From: Maria Tomalova <Maria.Tomalova@arun.gov.uk>
Sent: 20 July 2020 18:36
To: Planning.Responses <Planning.Responses@arun.gov.uk>
Subject: FW: BR/128/20/DOC, 9 Westloats Lane

From: Maria Tomalova <Maria.Tomalova@arun.gov.uk>
Sent: Tuesday, July 14, 2020 1:43 PM
[REDACTED]
Subject: BR/128/20/DOC, 9 Westloats Lane

With regards to your application (condition 4) there is a comment of Drainage Engineer attached on our website to be considered:

Project Proposed soakaway Plan	Sheet 4
Date 13th May 2020	
Scale 1 : 500

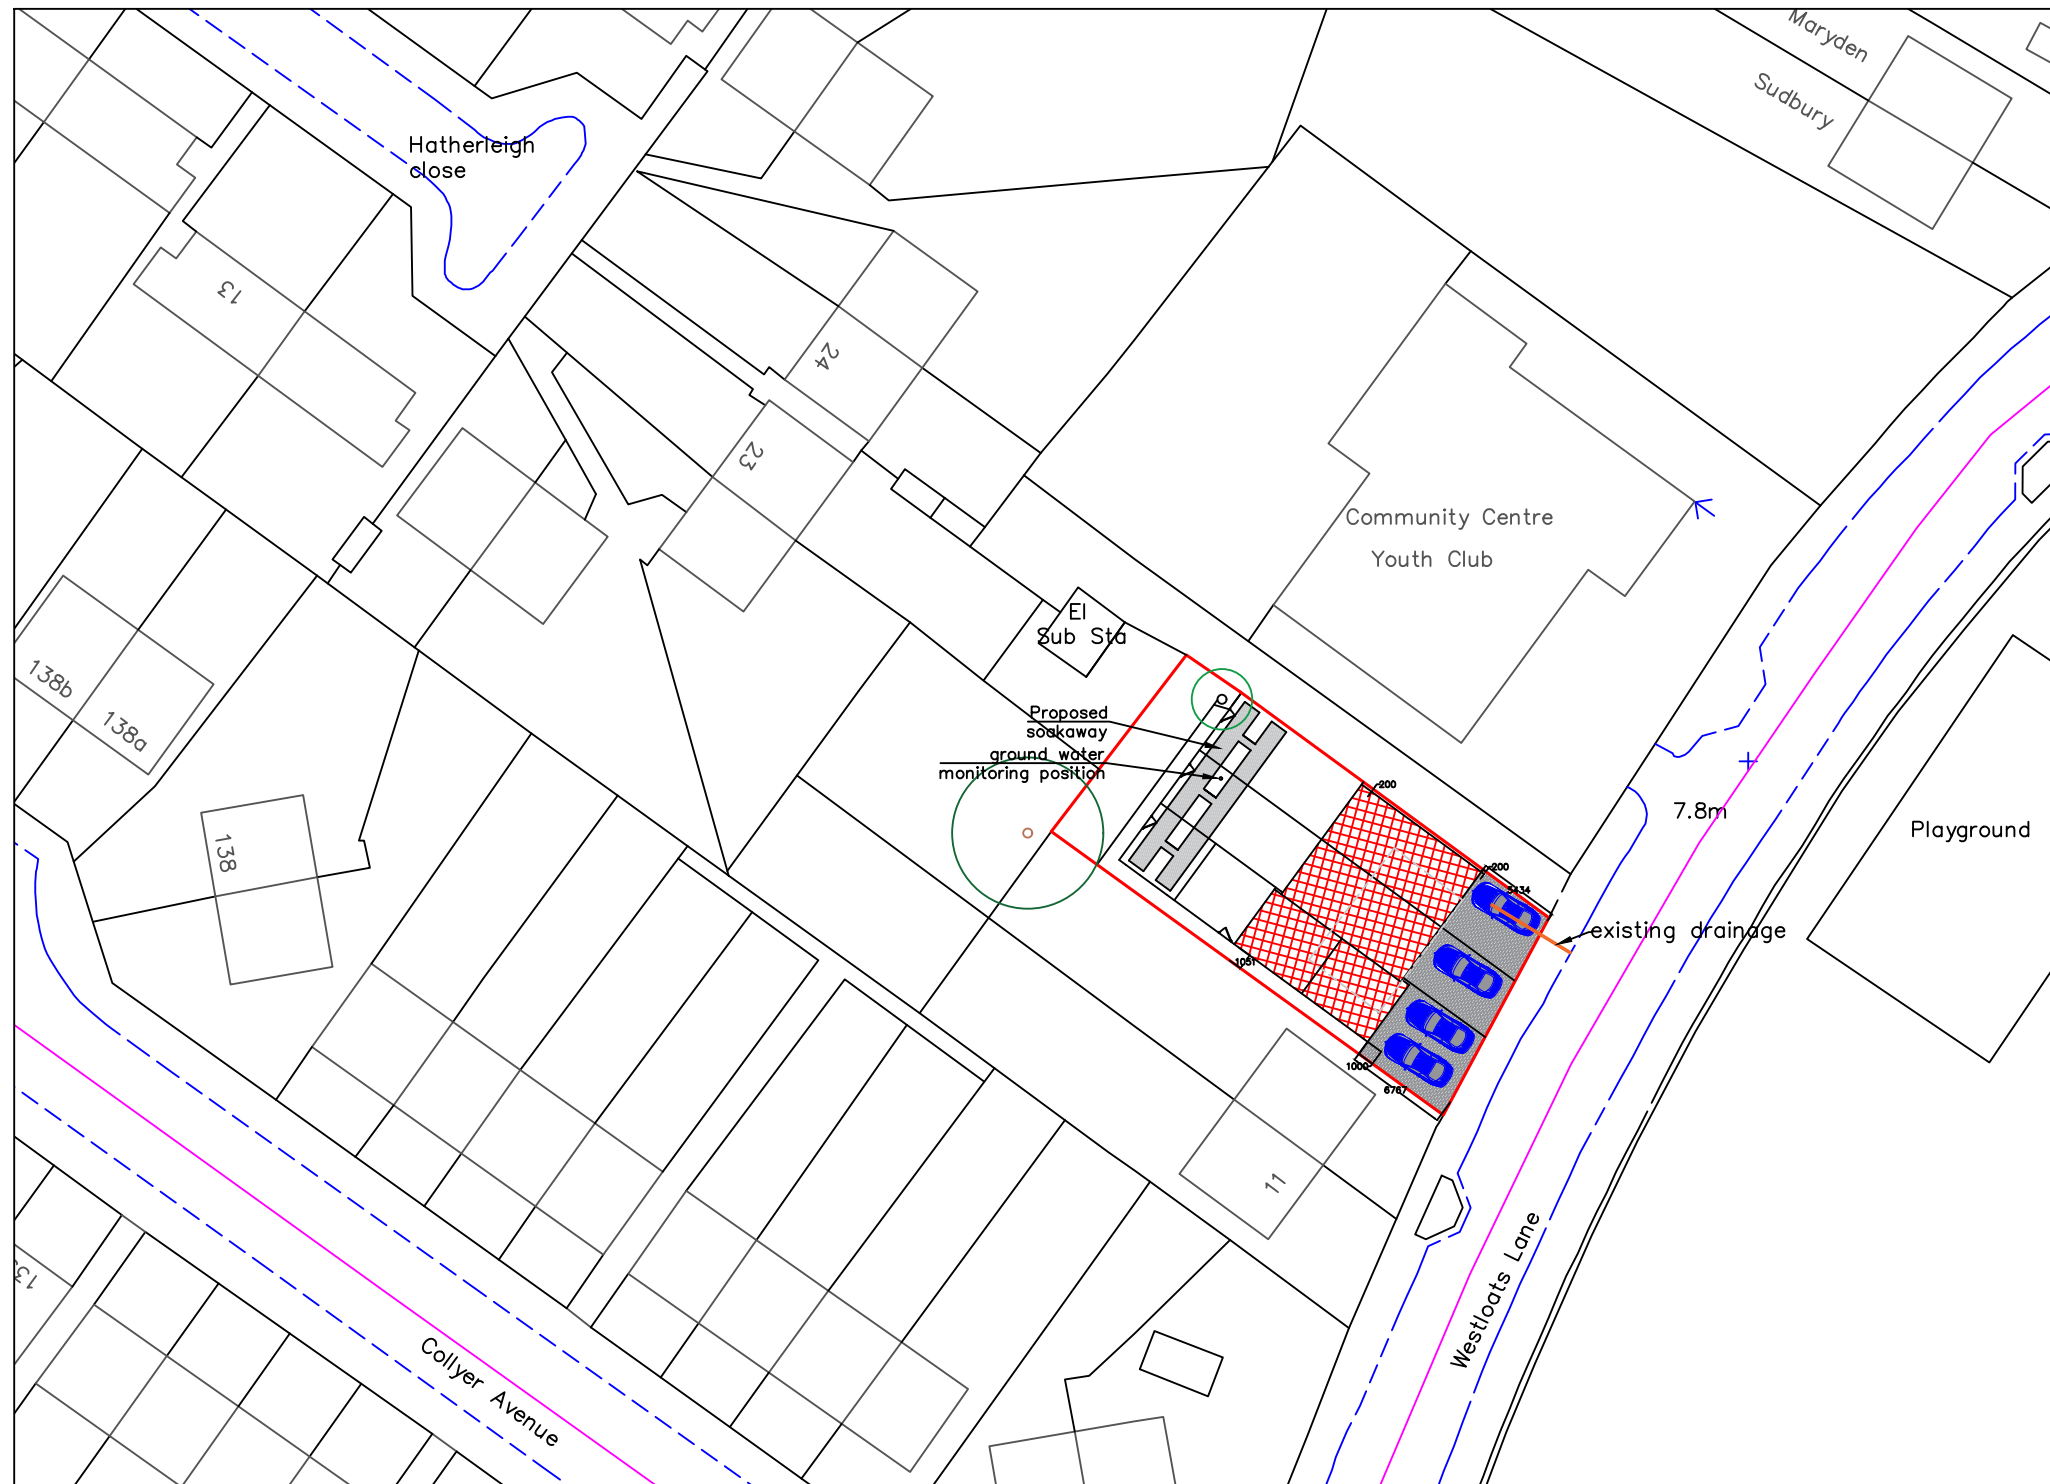
2. It also appears that only one infiltration test was completed. BRE 365 stipulates that the trial pit should be filled three times in succession and the worst rate used for the calculations.
3. Using an infiltration rate of 1.45×10^{-6} the half drain time for a ten year event (+40% climate change) exceeds 24 hours.
4. The Soakaway Plan does not include the necessary level of detail as described in the Drainage Checklist. (Pipes, silt traps/manholes/inspection chambers, invert levels, cover levels, gradients/falls).
5. No construction detail drawings have been supplied (Soakaway, silt trap, pipe bed and surround minimum).
6. Permeable paving is noted on the site plan, but there are no calculations for this. Nor is it included in the drainage layout. Nor do we have a construction detail for it.
7. Any soakaways need to be kept a minimum of 1.5m from the property boundaries.

- 1, The calculation is correct Sarah made an error
- 2, Three tests were carried out and the worst case was used, the other tests are now noted on the calculation sheets.
- 3, Using the correct infiltration figures I supplied this does now drain within 24 hours
- 4, See attached new plan
- 5, see attached new plan
- 6, Permeable paving is shown on the plan and construction details from Marshalls are attached, they are not included in the calculations as no surface water from these areas is added to the drainage system.
- 7, Drawing amended to take this into account
